DOC18/354117
SSD 8882

Orange Grove Sun Farm - SSD 8882

OEH review of Orange Grove Sun Farm EIS

Figure 2 Site Layout, Locality and Drainage Features

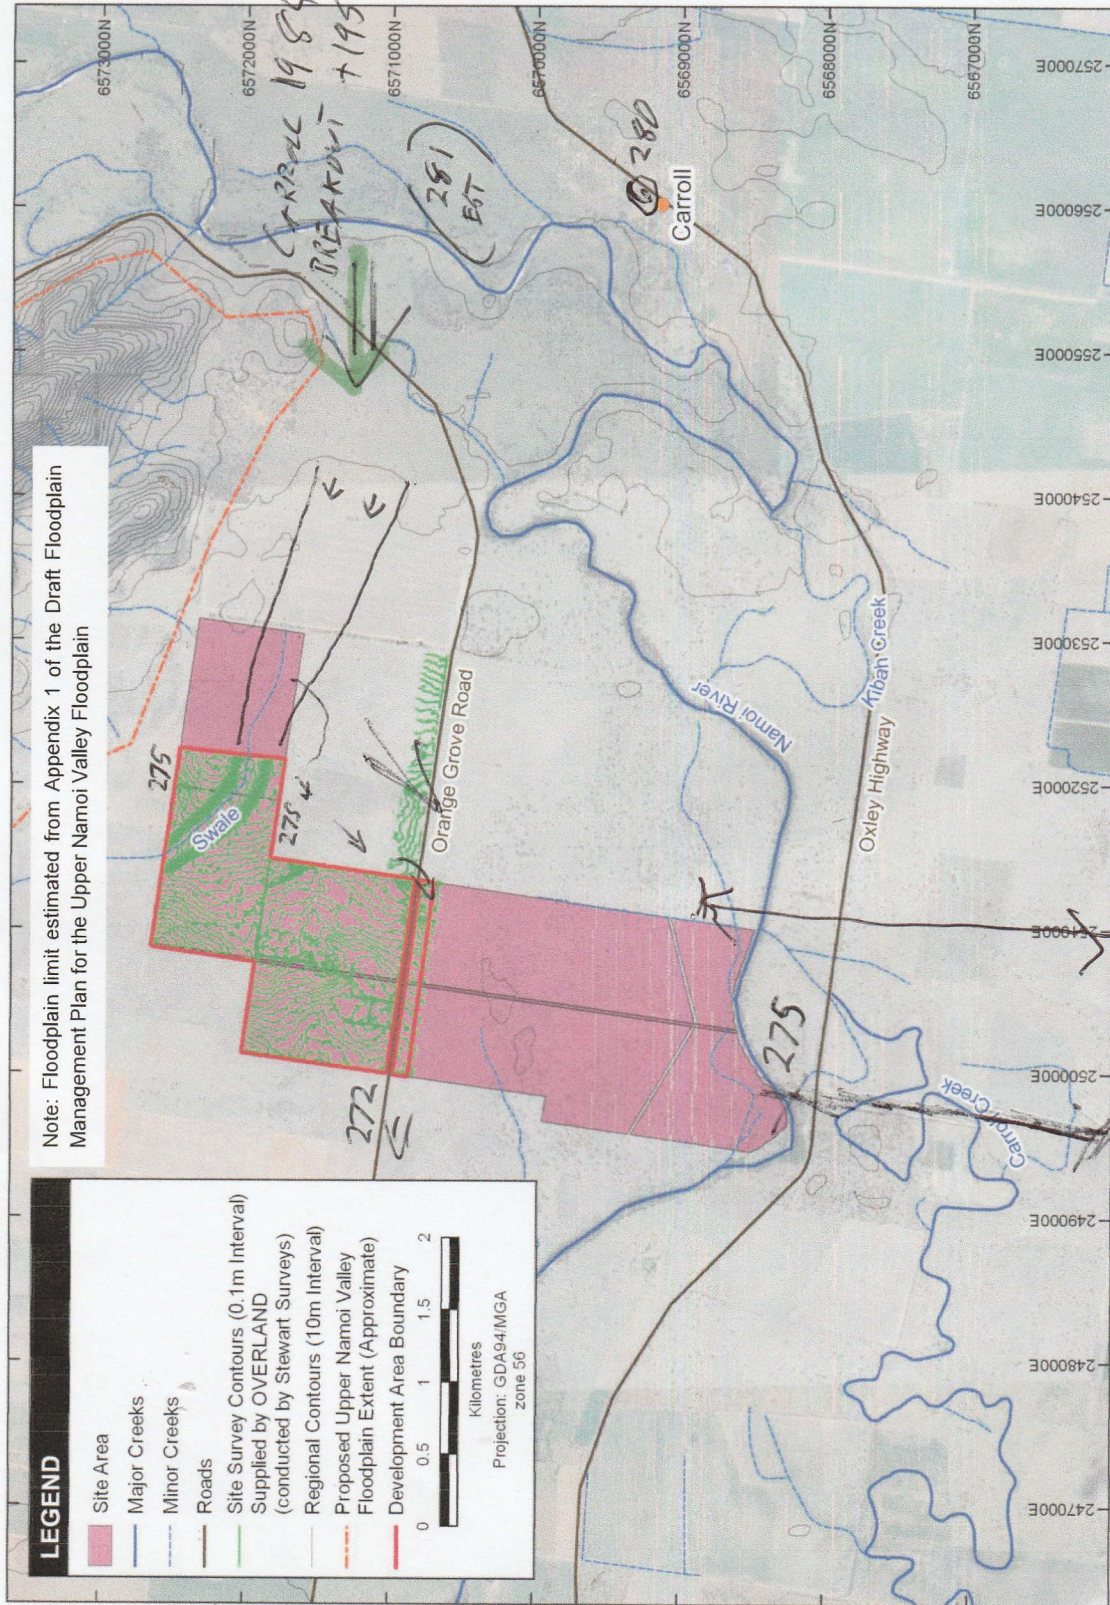
The Carroll to Boggabri Floodplain Management Plan and flood study have identified a flow path or flood runner which traverses across the north-east portion of the development area. Fencing which collect debris may have impact on flood behaviour.

The assessment only looked at a flood level in the Namoi River adjacent to the development and did not consider the two-dimensional nature of flooding and previous studies which identify a flow path travelling to the north west from the Namoi River.

- 5.1 Further discussion is required on the impact of the development on flooding, especially the impact due to fencing and debris which may collect on the fences.
